Application for Planning Permission for Works or Extension to a Dwelling

Development: Extension to the side and infill extension to the rear, new roof and loft conversion and alterations to fenestration including removal of front porch.
Location: 51 Warren Crescent East Preston BN16 1BL

3 Proposed Block Plan

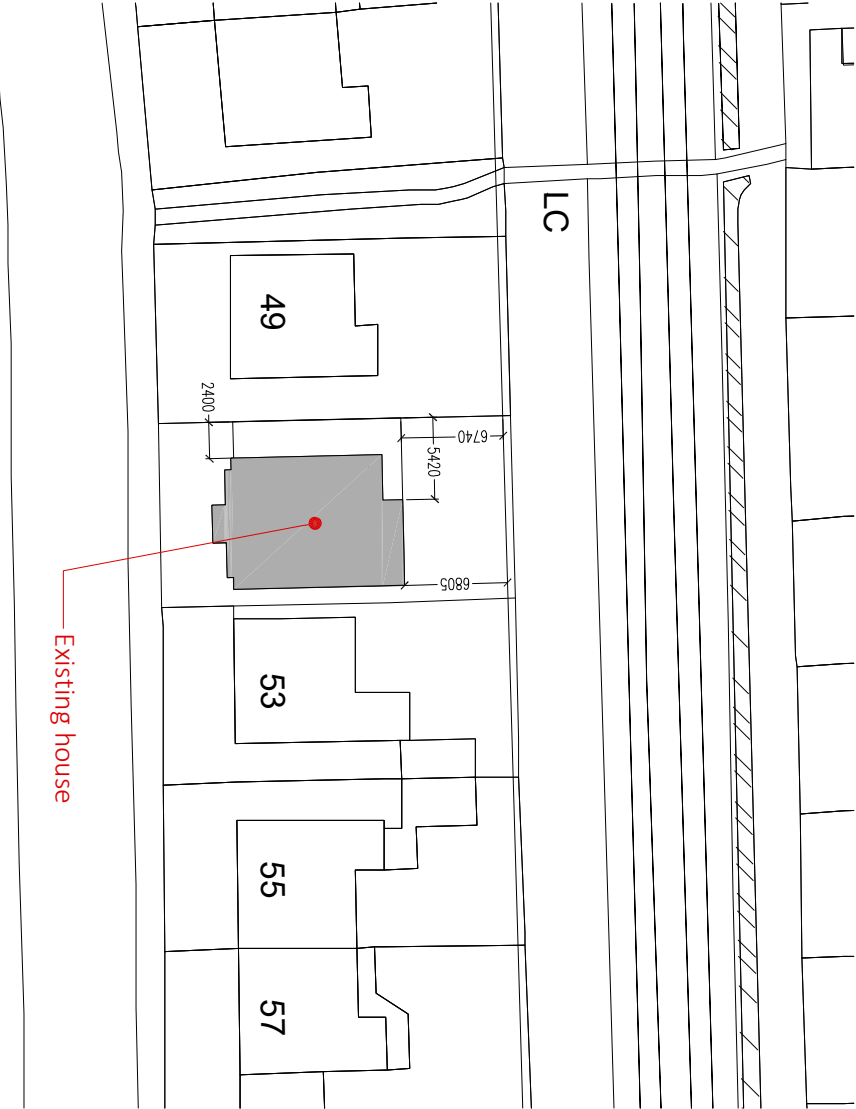
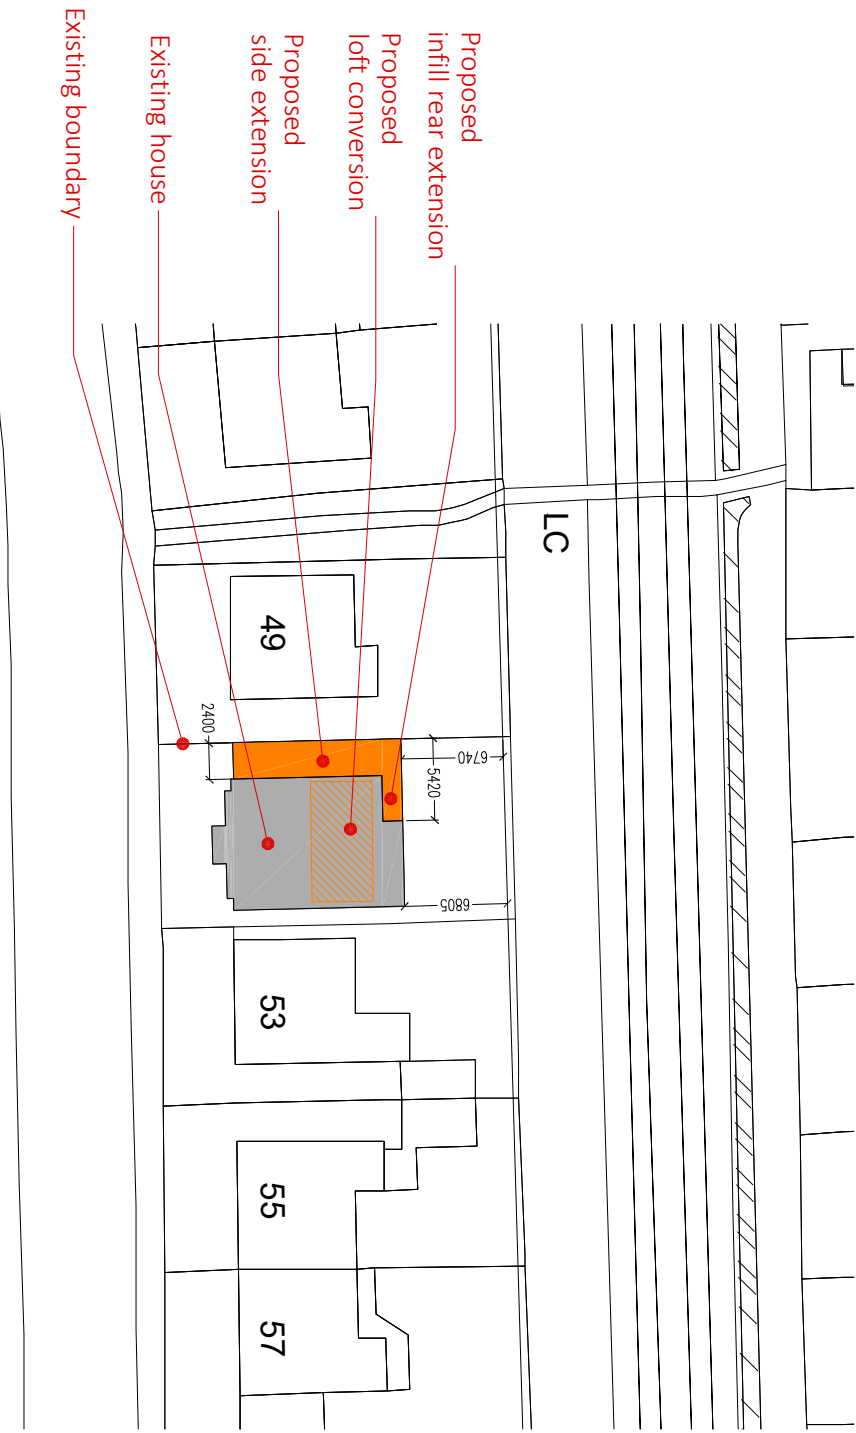
The proposed extensions within block plans require dimensions to the boundary. Please amend.

Project ARCH2026_WaCl-R	Sheet
Date 30.06.2026	A103-B
Scale as stated	
PRELIMINARY ISSUE

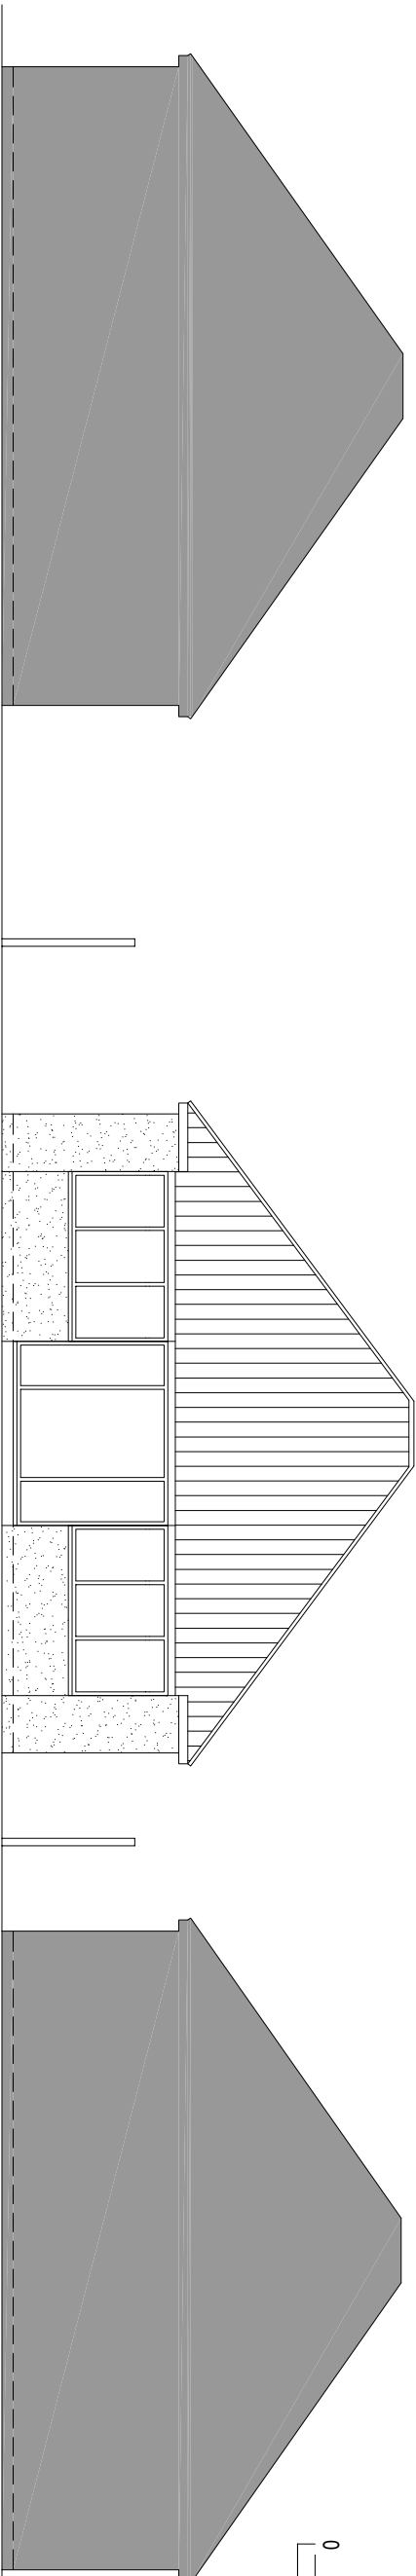
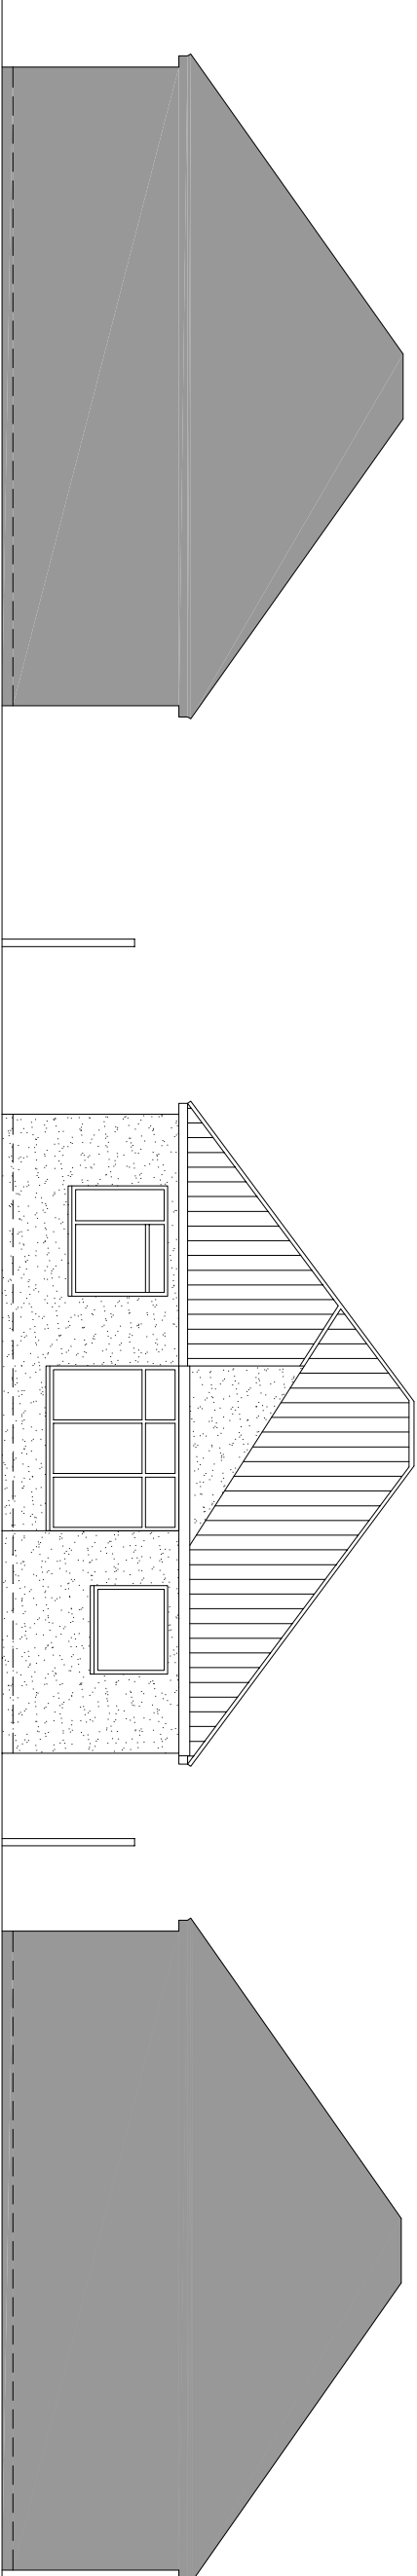
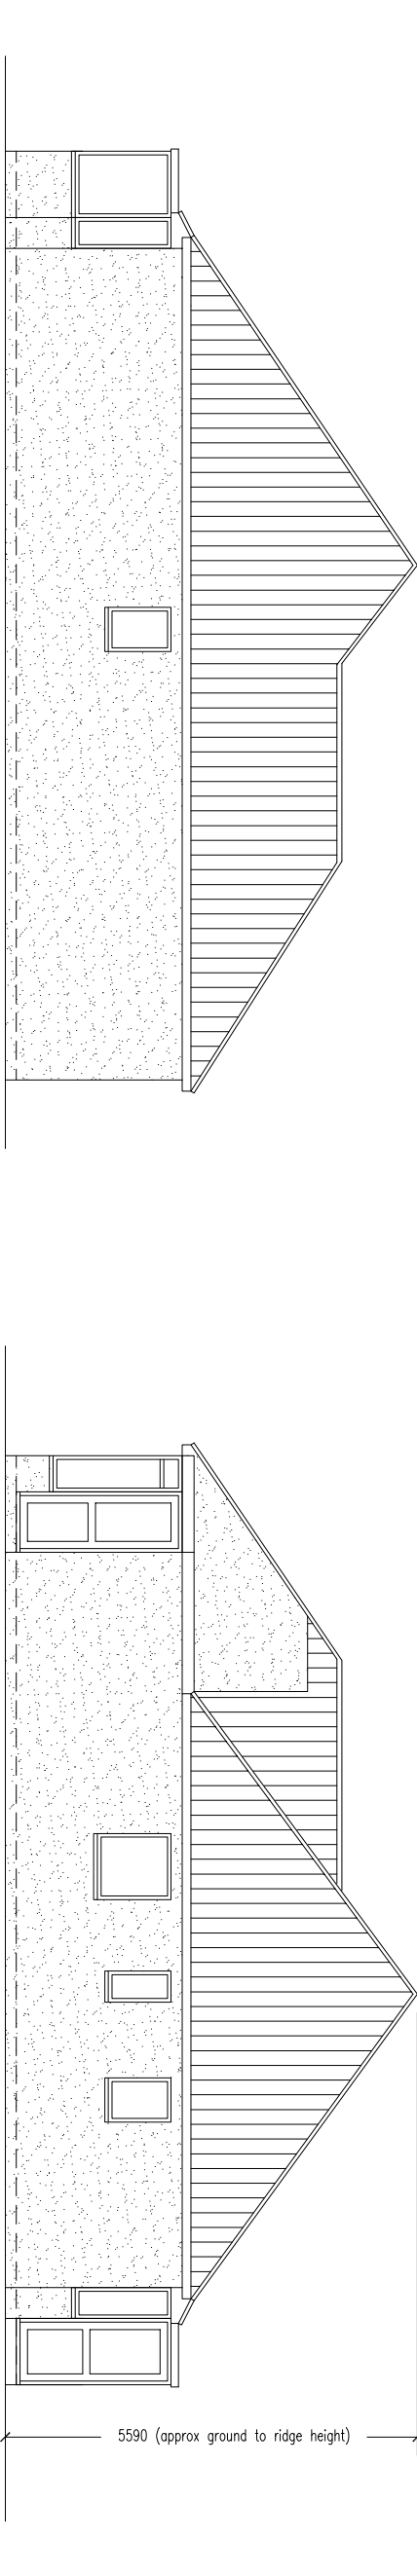
Elevation plans A103 are labelled as proposed, these appear to be existing plans, please review and amend.

1 Proposed ground floor plan

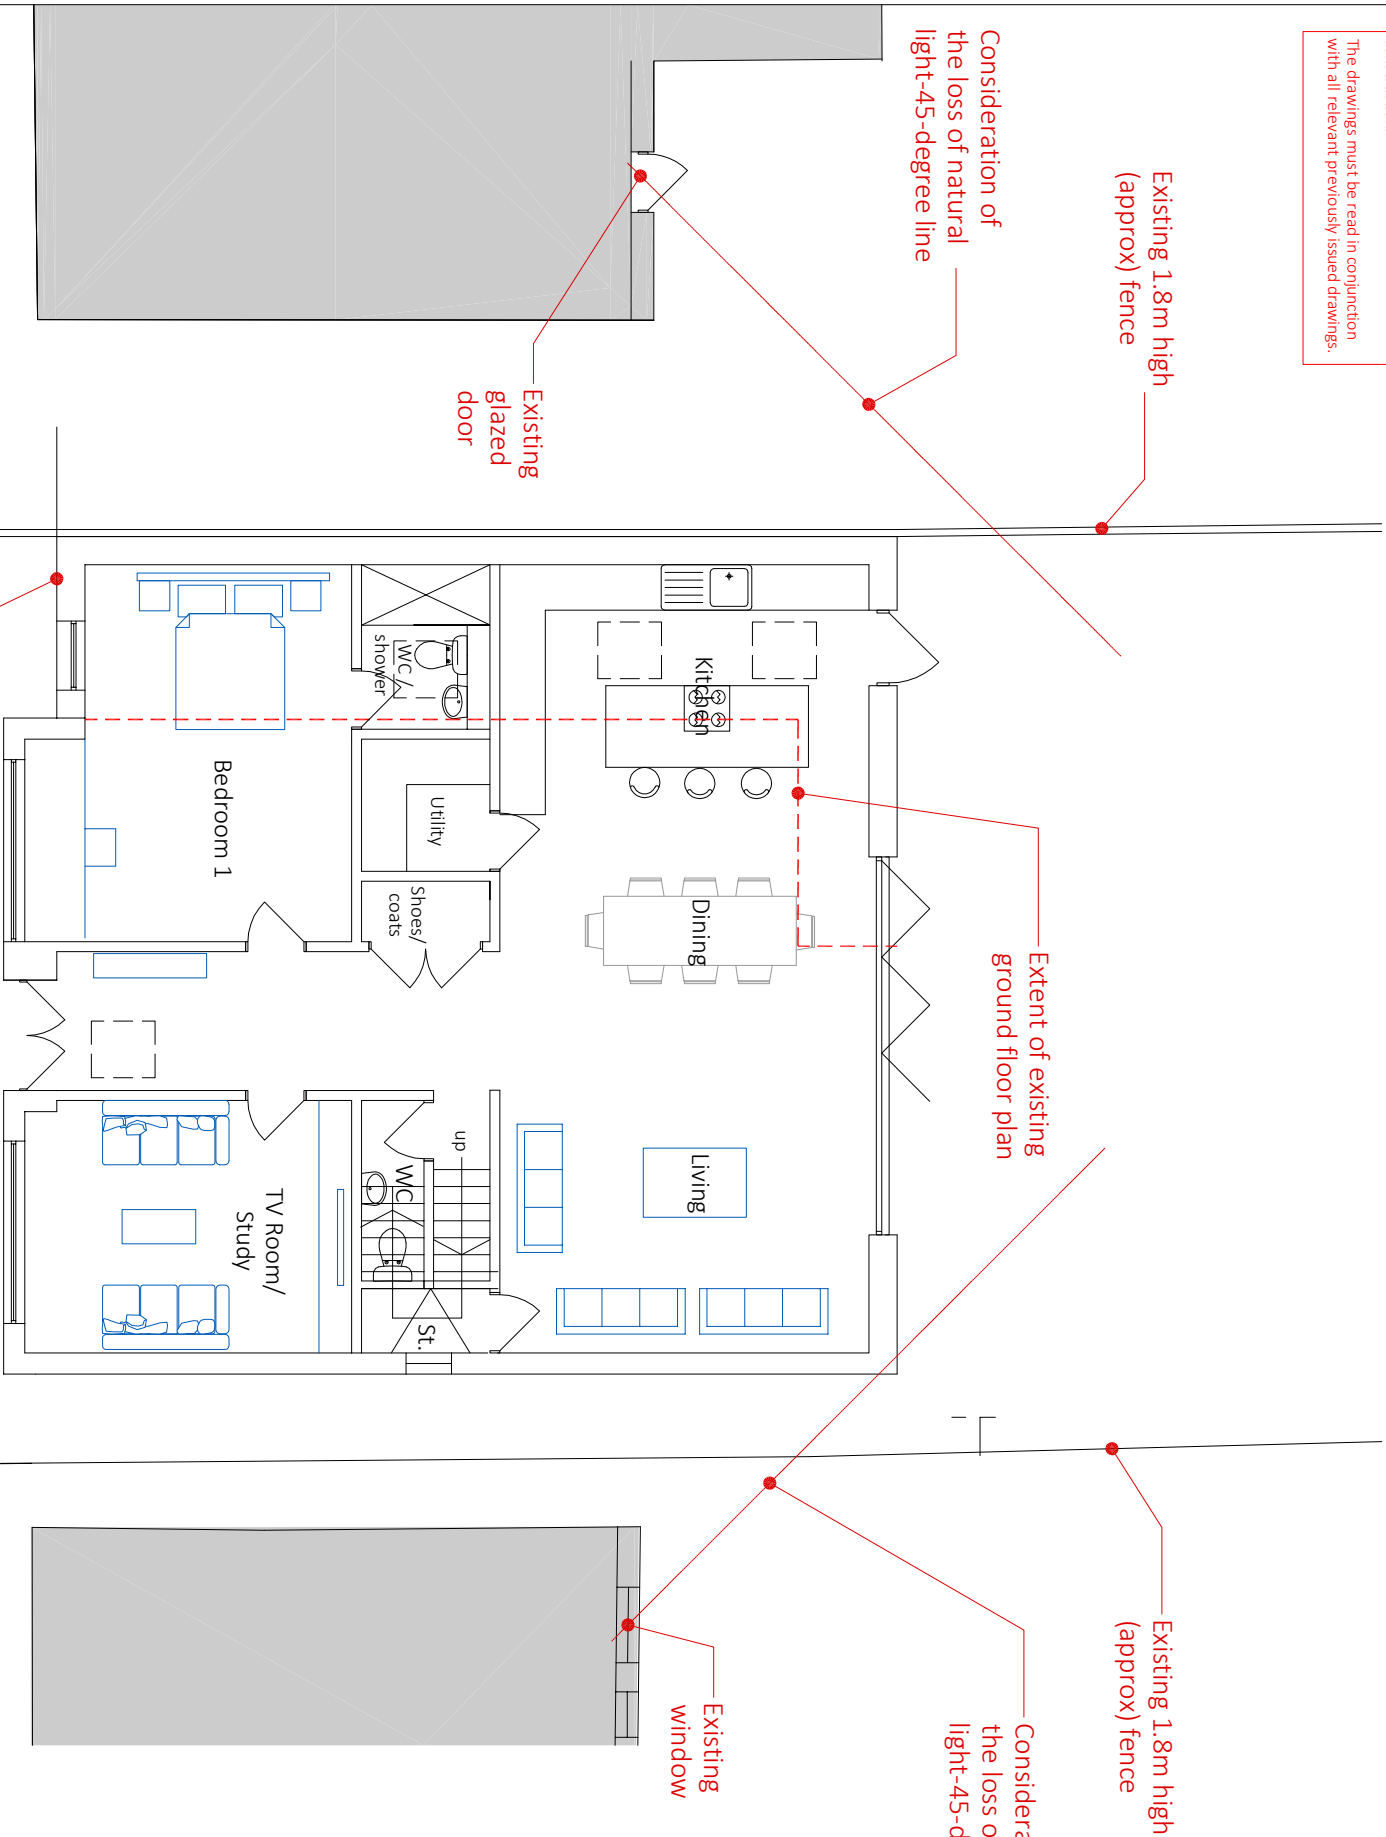
Fenestrations on proposed east side of ground floor plan are inconsistent with proposed east side elevation plan.
